M3 JUNCTION 9 NATIONALLY SIGNIFICANT INFRASTRUCTURE PROJECT

Written Summary of Oral Submissions

Issue Specific Hearings 1, 2 and 3

18 August 2023

**DRAWING TITLE**  
 FIGURE 2.5 - THE SCHEME: TEMPORARY TRAFFIC DIVERSION ROUTES  
 APFP REGULATIONS 5(2)(a)  
 SHEET 1 OF 12  
 DOCUMENT REFERENCE 6.2

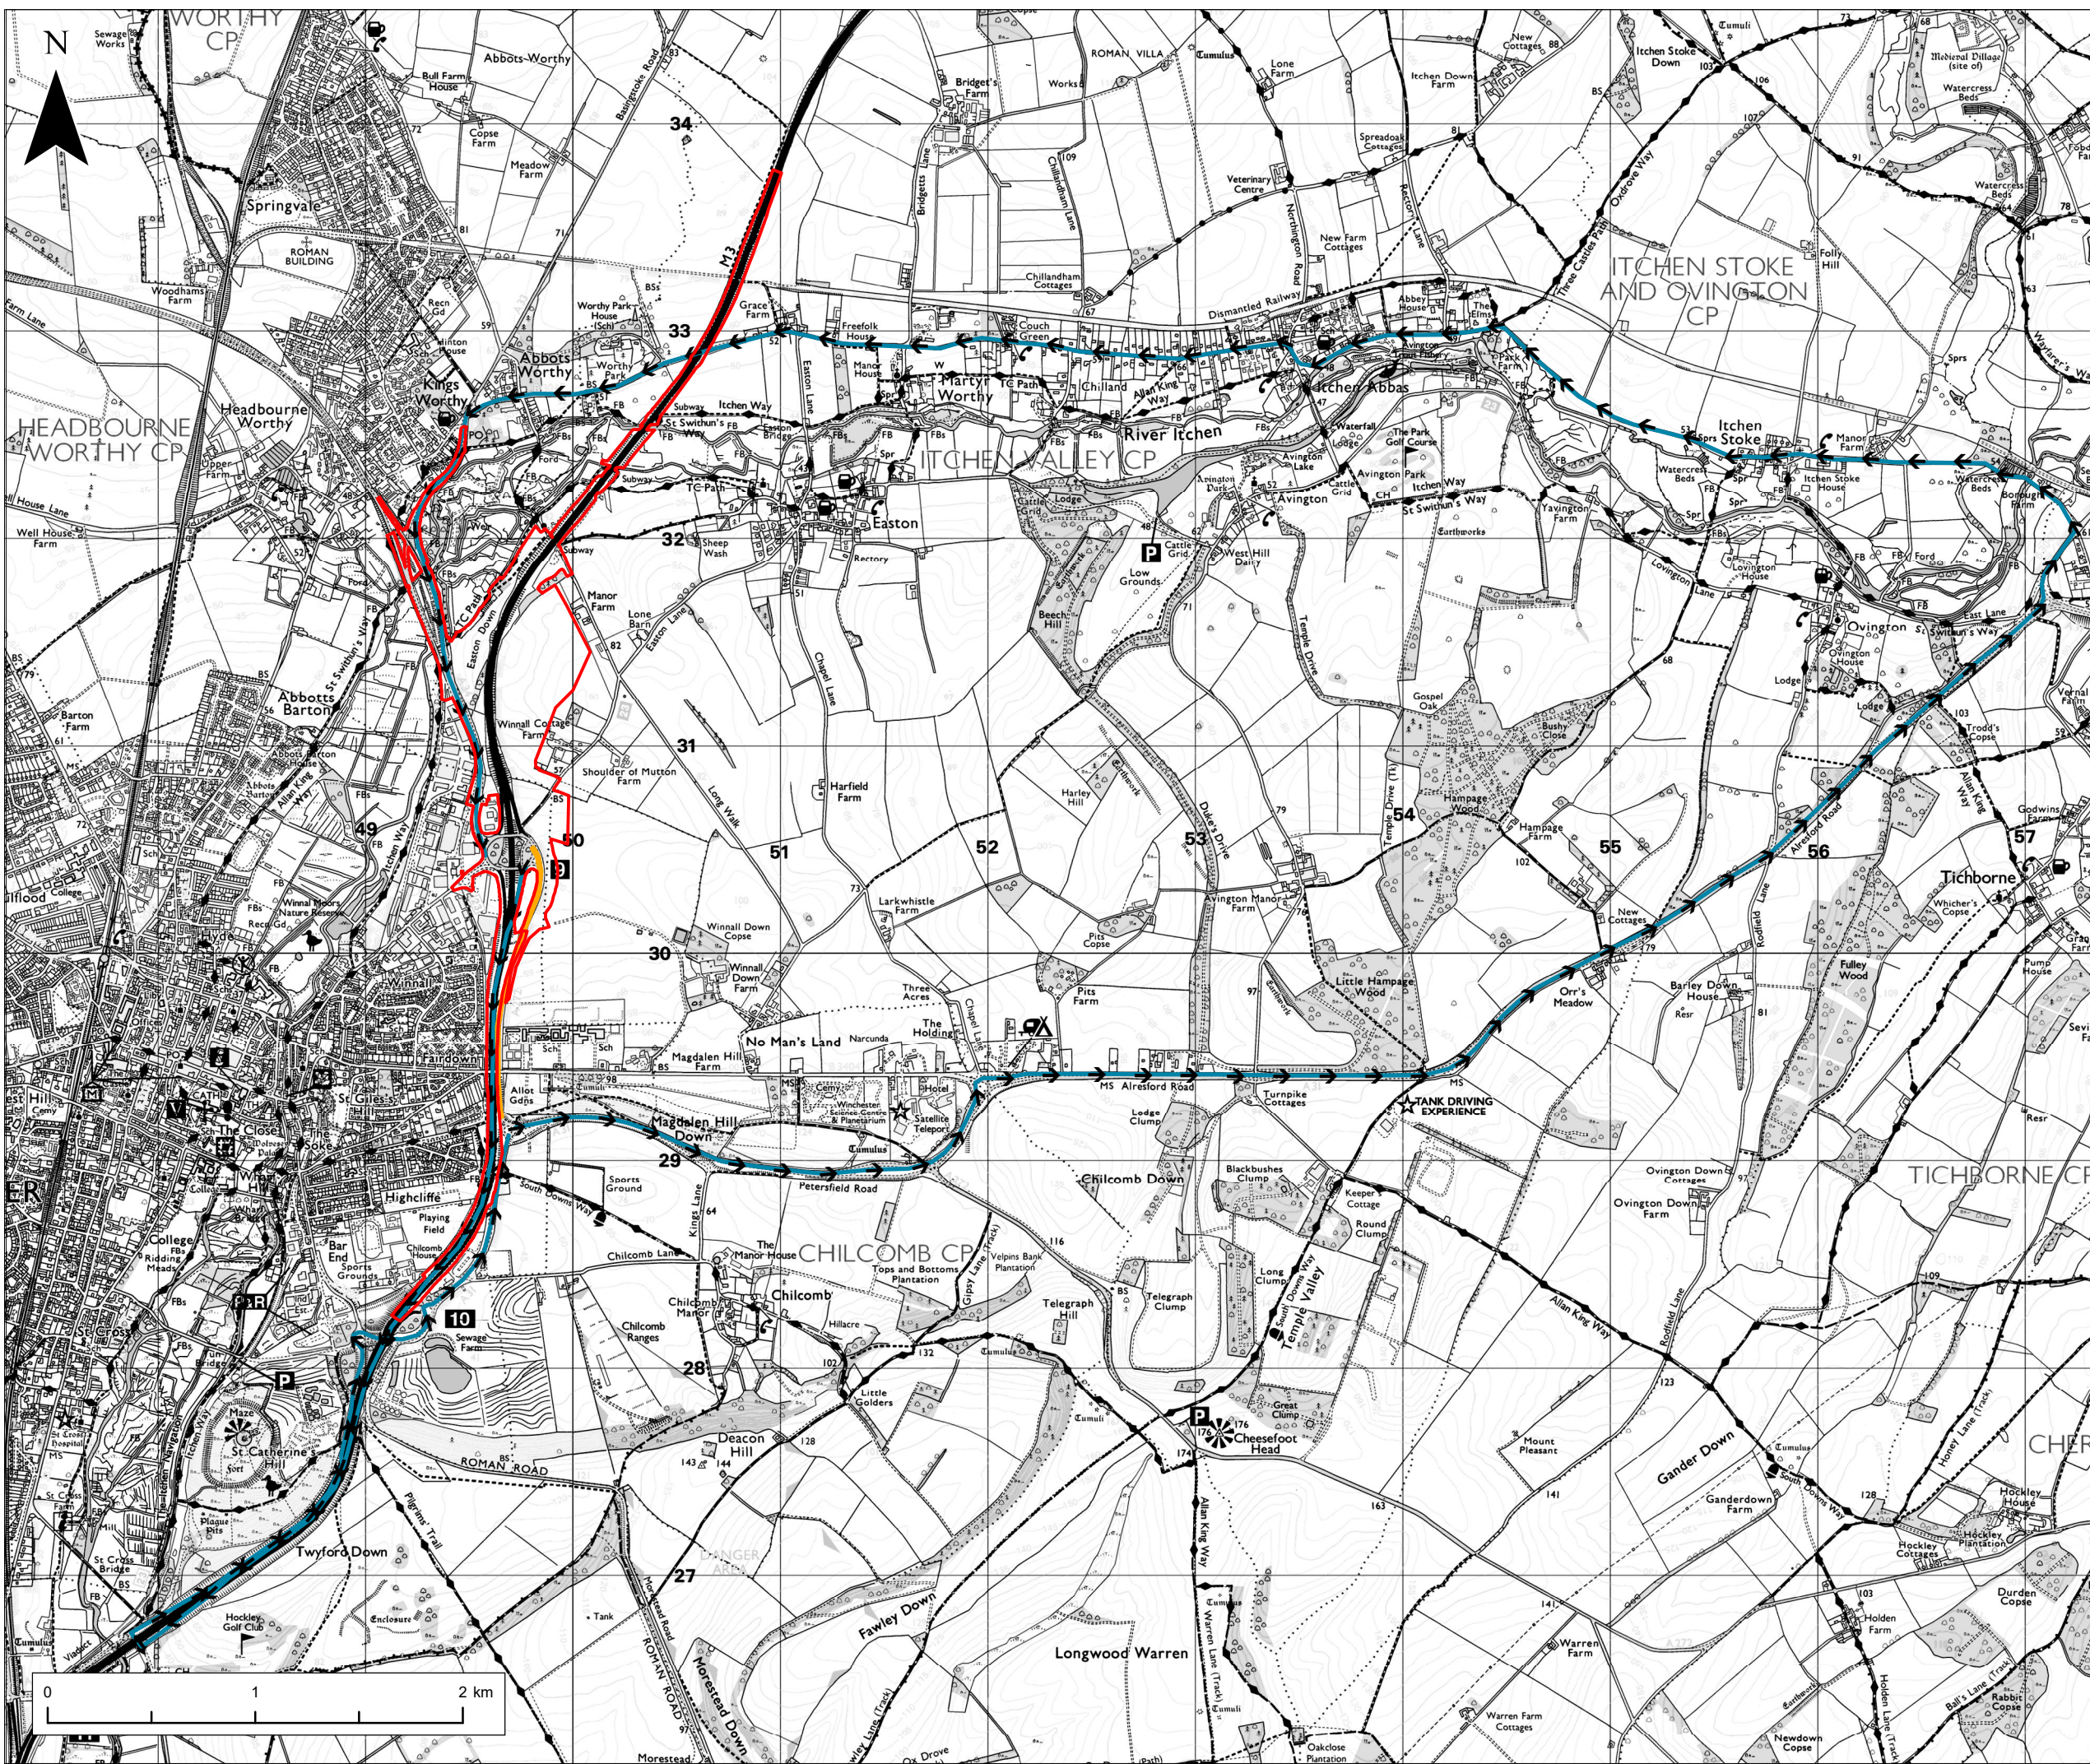
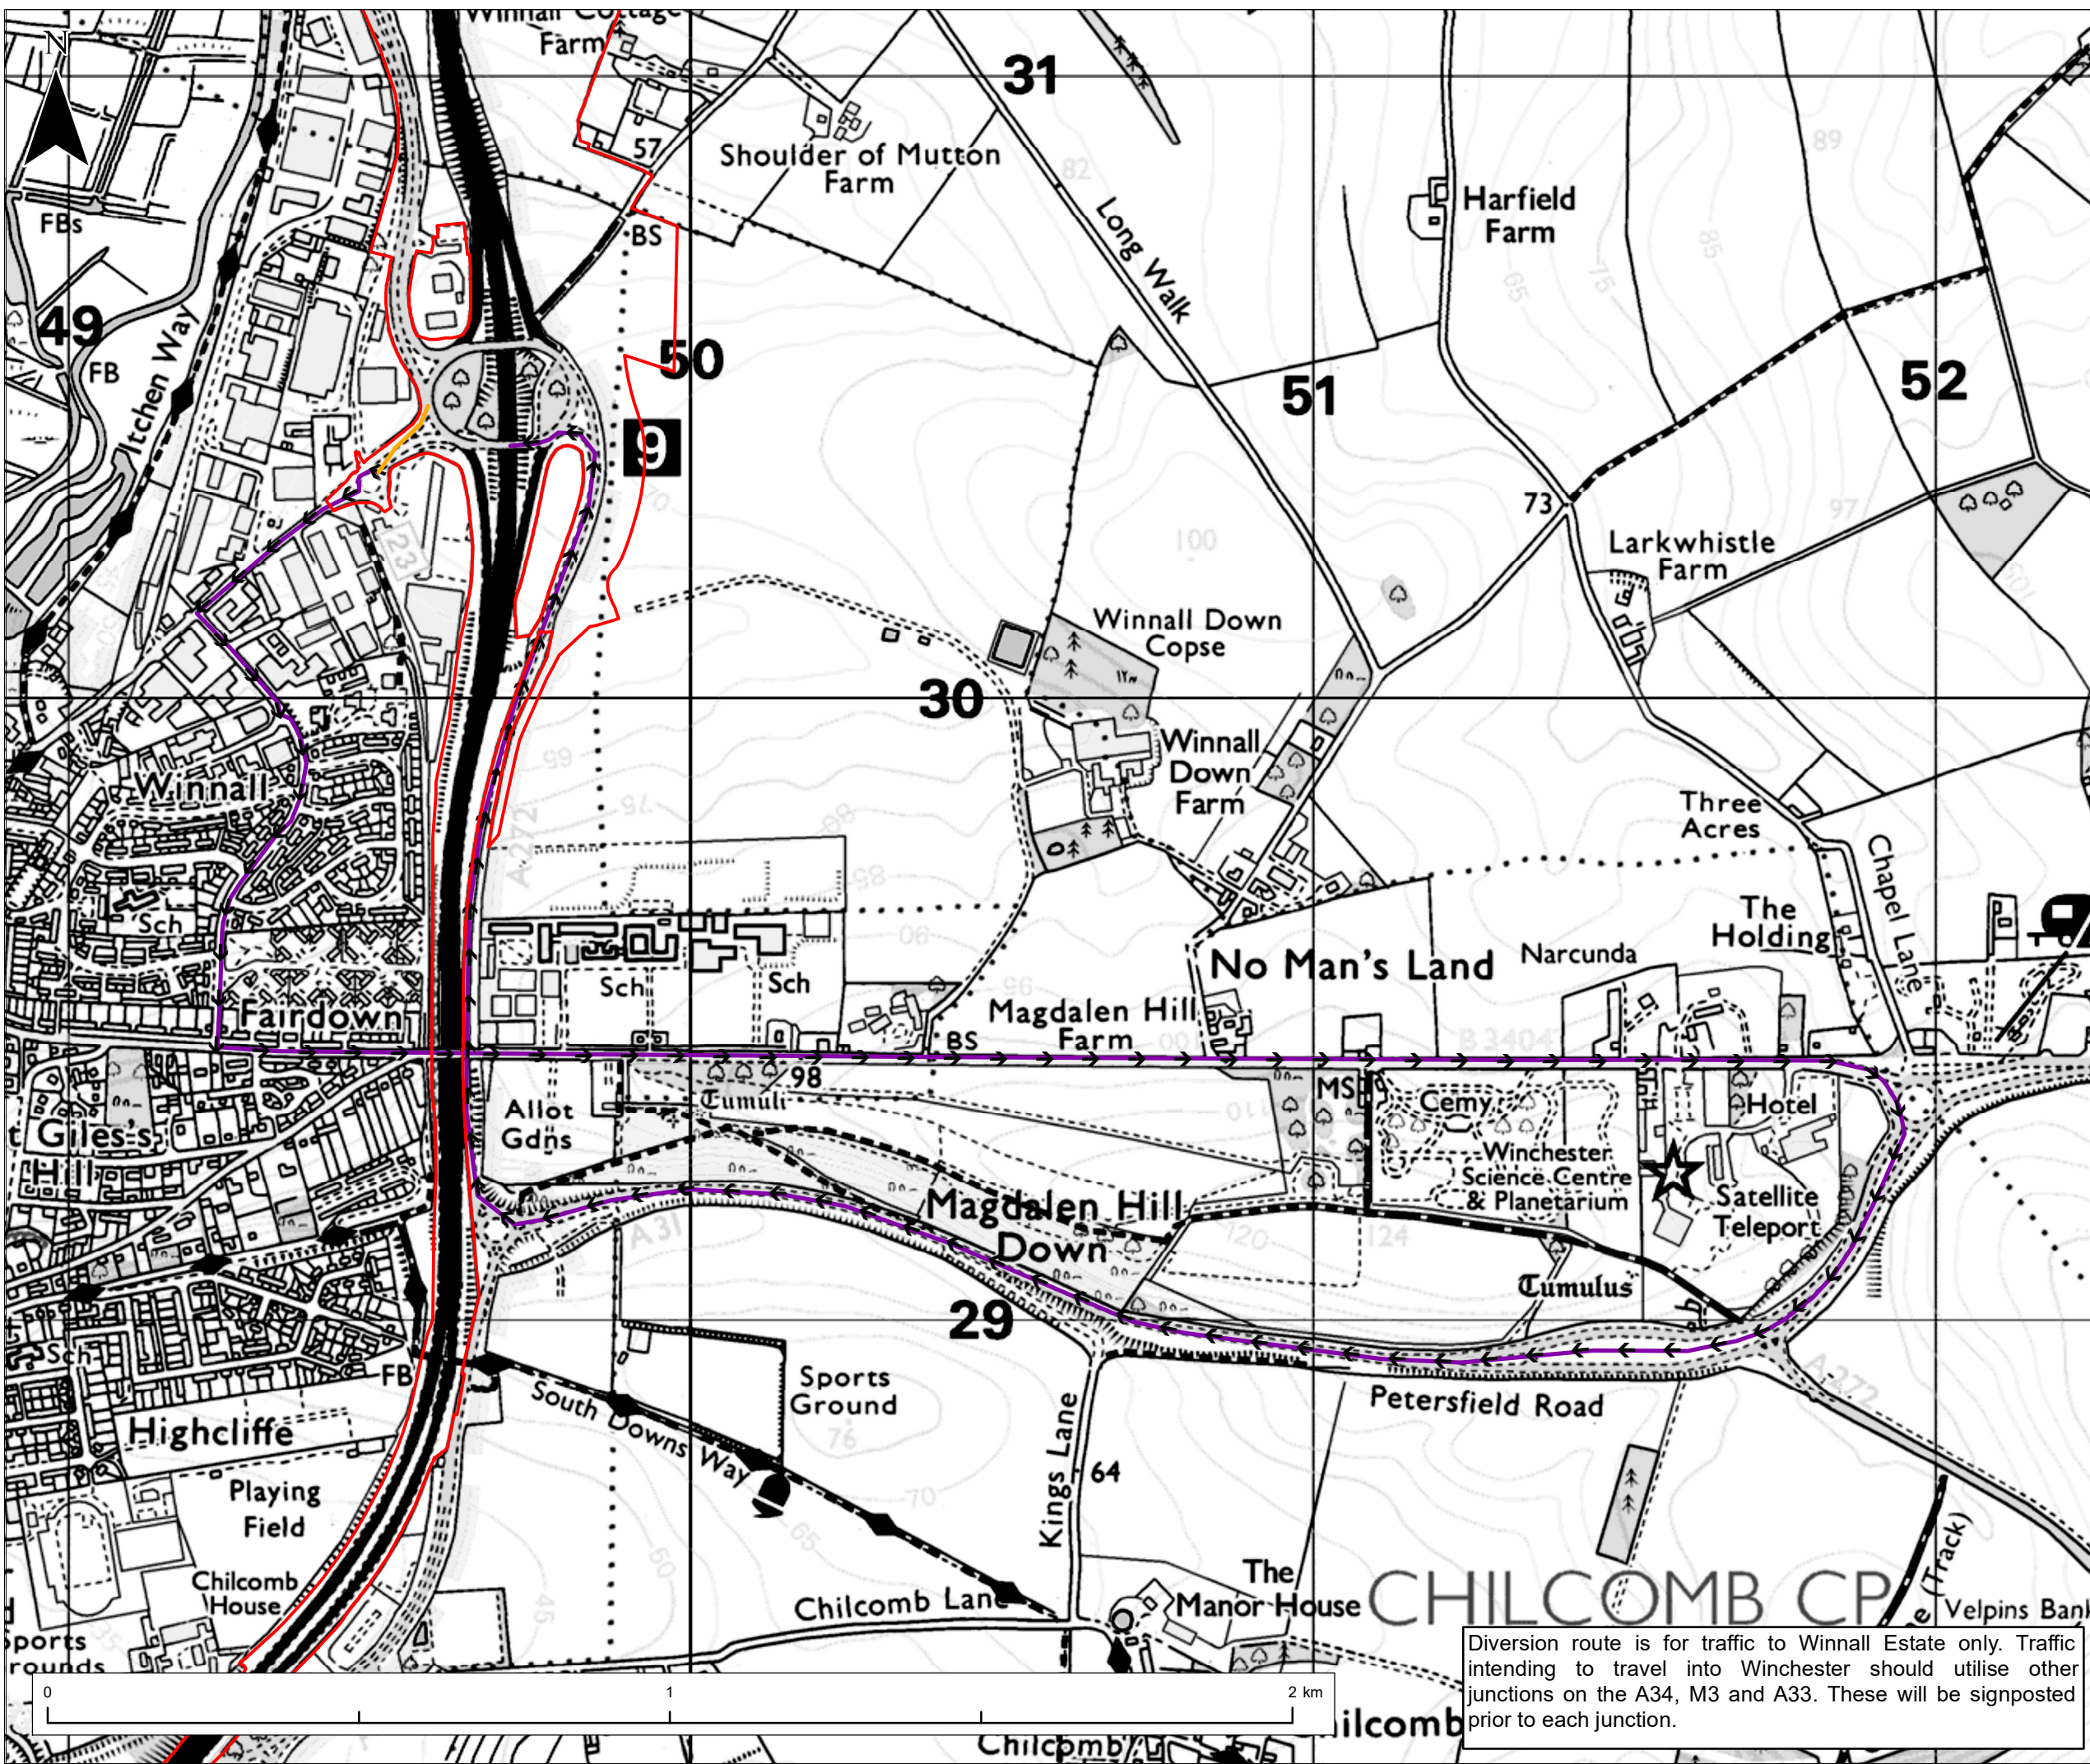
2.2.4 The City Council notes the points raised by the County Council and applicant during ISH2 which confirmed on-going discussions regarding appropriate diversion signage

(including advanced positioning, instructions not to follow sat-nav). The City Council has raised concern on the effectiveness of the diversion routes and will discuss this matter further with the County Council as Highway Authority.

2.2.5 Concerning the diversion of the Junction 9 northbound on-slip, which is required to travel southbound and then use Junction 11 for 17 months, the City Council concern relates to traffic signalling.

It is presumed that to accommodate the additional traffic using Junction 11, the signals for the M3 southbound off-slip traffic will be prioritised. This would result in increased delays for those held at traffic signals on the B3335 toward Twyford and along the Hockley Link. There is a significant pedestrian crossing on the Hockley Link serving the Itchen Way which will have to navigate the additional congestion.

The applicant confirmed at ISH2 that no traffic light alterations are proposed however this will be subject to monitoring. The City Council request clarification on the process which will be followed in the event that traffic signals are altered.
